ASSESSMENT REPORT

Section 75W Modification Woodlawn Waste Management Facility DA 31-02-99 MOD 3 and MP 10_0012 MOD 2

PROJECT	WOODLAWN LEACHATE TREATMENT PLANT
TITLE	SITE PLAN - TP SCHEDULE

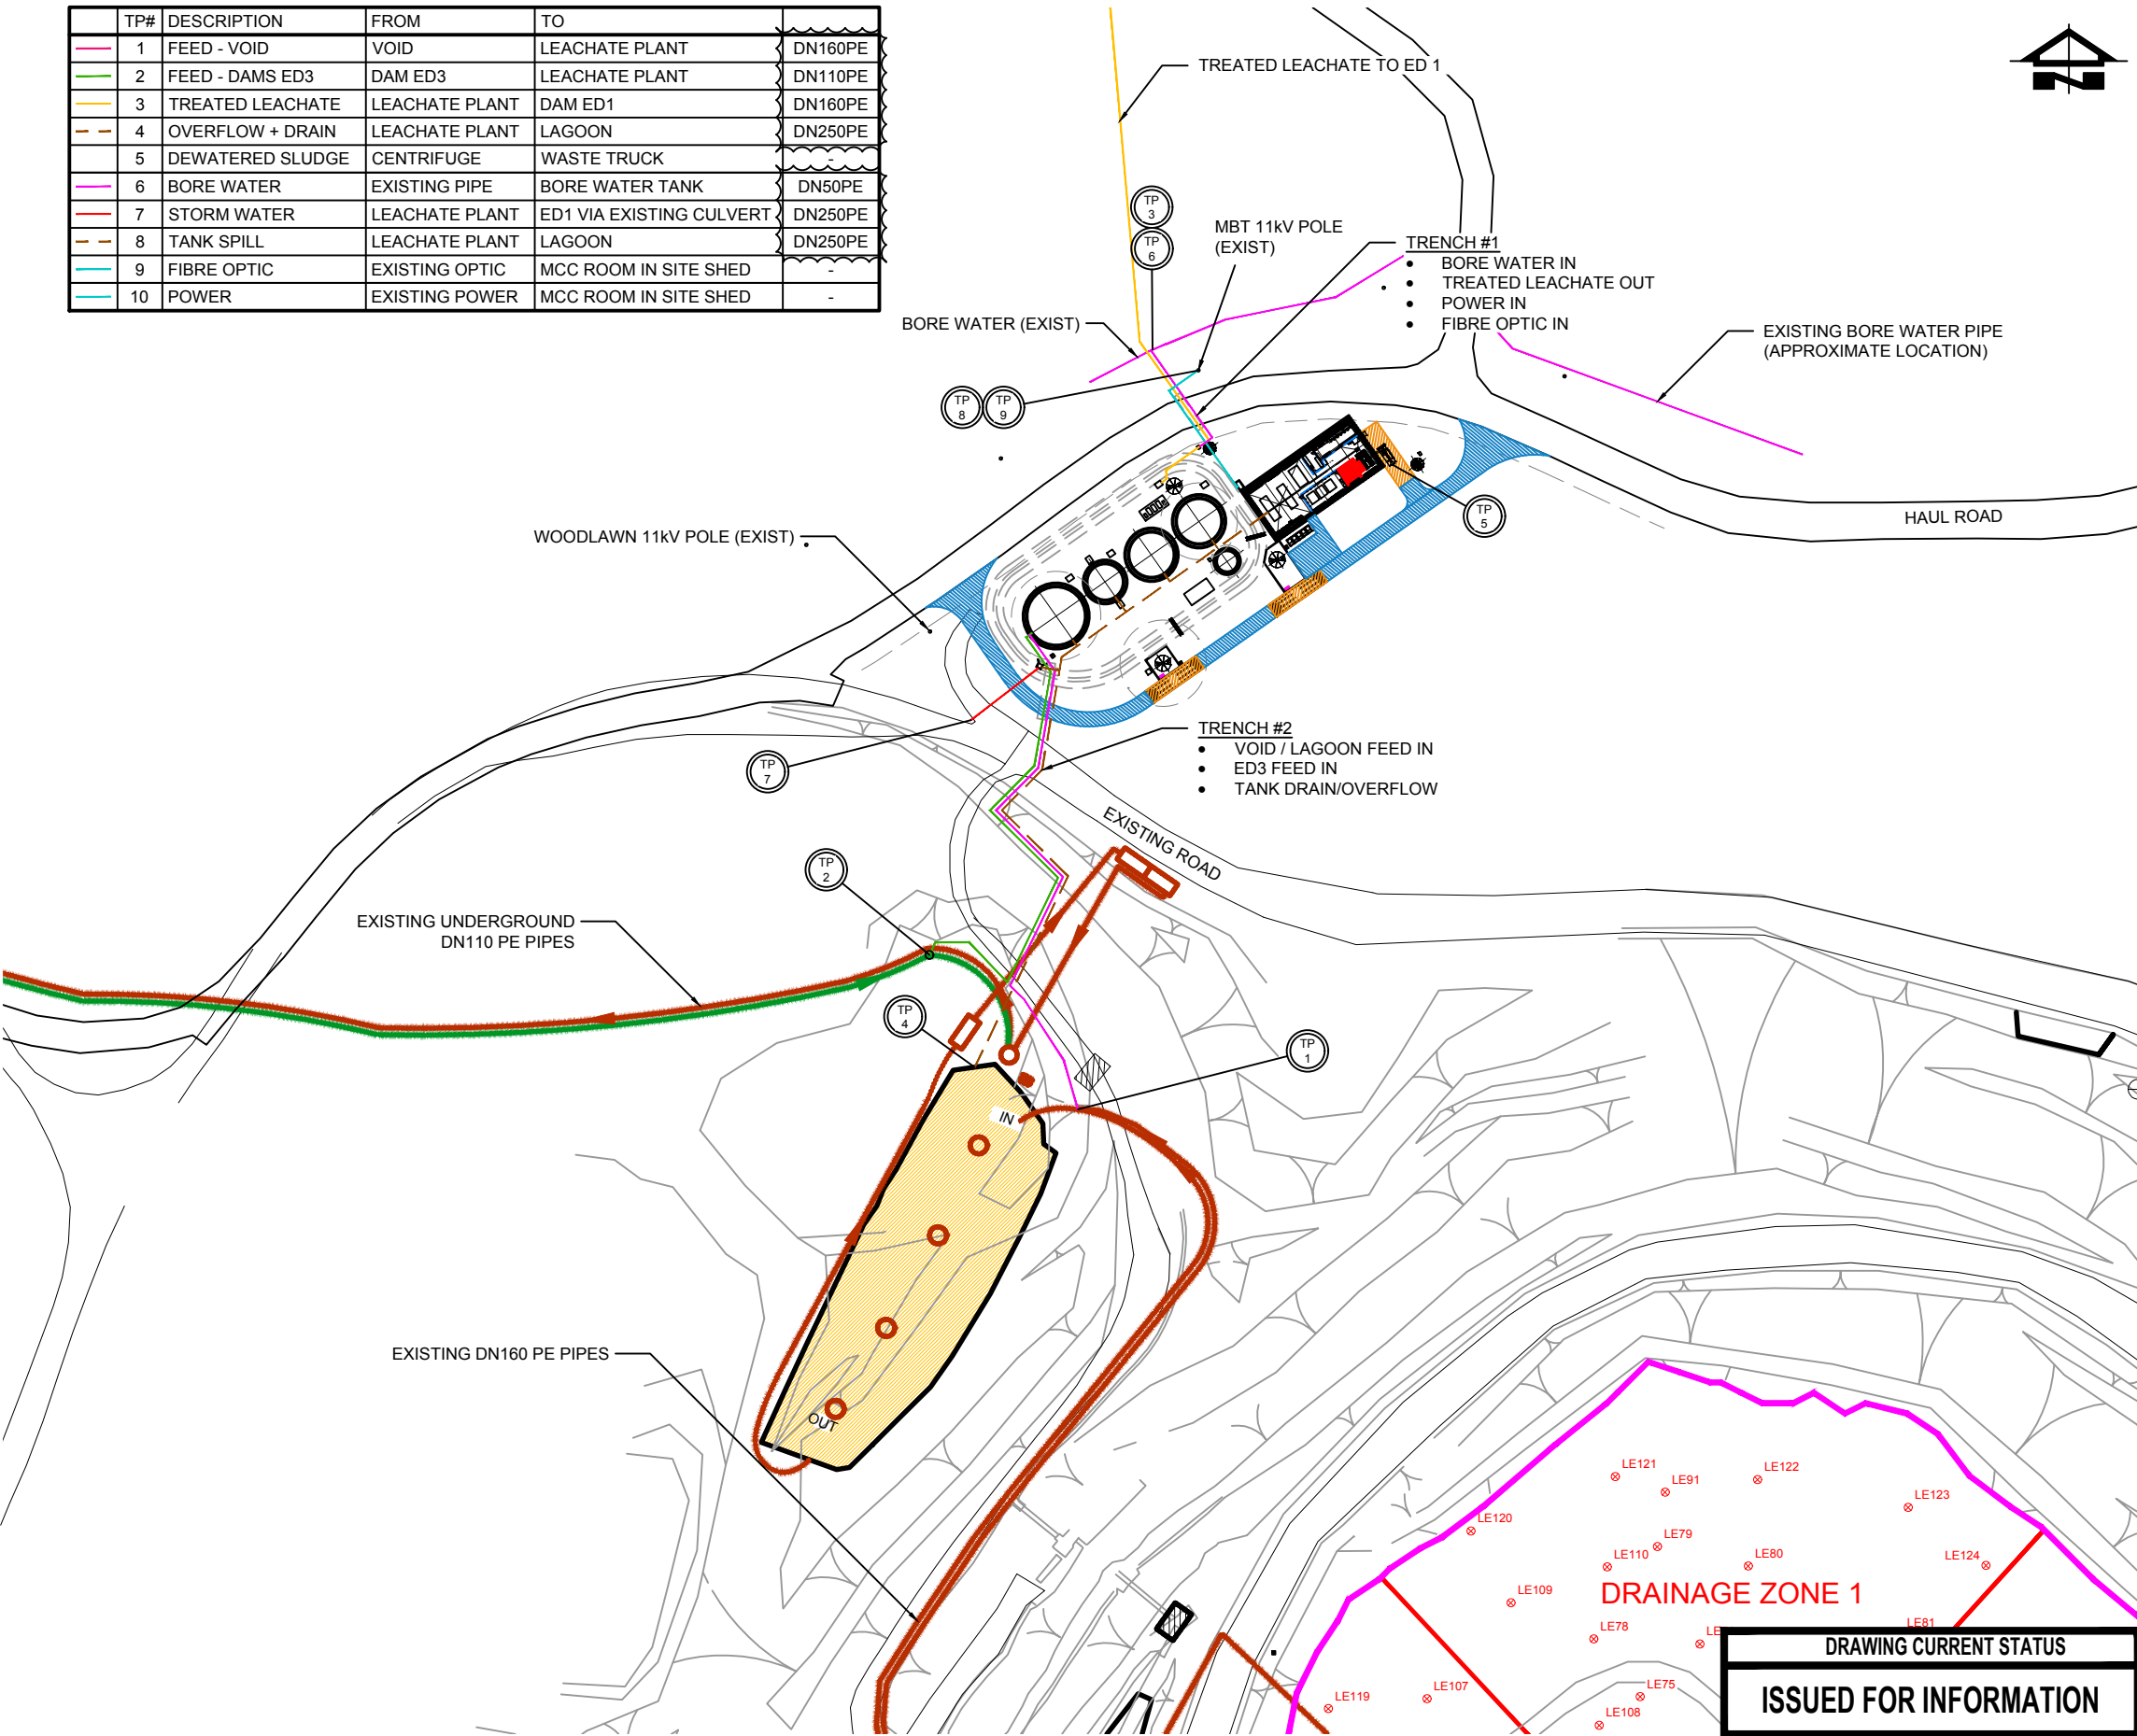
- the coffer dam should be lined with high-density polyethylene (HDPE)
- the LTP must be capable of treating leachate continuously at 4 L/s including the measures that would be employed to maintain treatment capacity during maintenance periods

In addition to the above, the Department raised concern with the assumptions in the water balance, the management of leachate in ED1 and the changes to the regional waste limits and the lack of contingencies proposed. The Department requested that the proposed coffer dam in ED1 be lined with a HPDE liner. The Department requested further information about the construction of the coffer dam and pipeline and requested further justification to the proposed changes to the regional waste limits.

- ED1 would be managed by the Proponent whilst ED2 would be managed by Heron and there would be no transfer of treated leachate between the two dams
- the LTP would be capable of processing leachate at a rate of 4 L/s

On 28 November 2017, the Proponent submitted a revised LTP layout plan (see **Figure 7**). In addition, on 12 December 2017, the Proponent submitted a revised Construction Environmental Management Plan (CEMP) which detailed how the construction impacts of the LTP, pipeline and coffer dam would be managed.
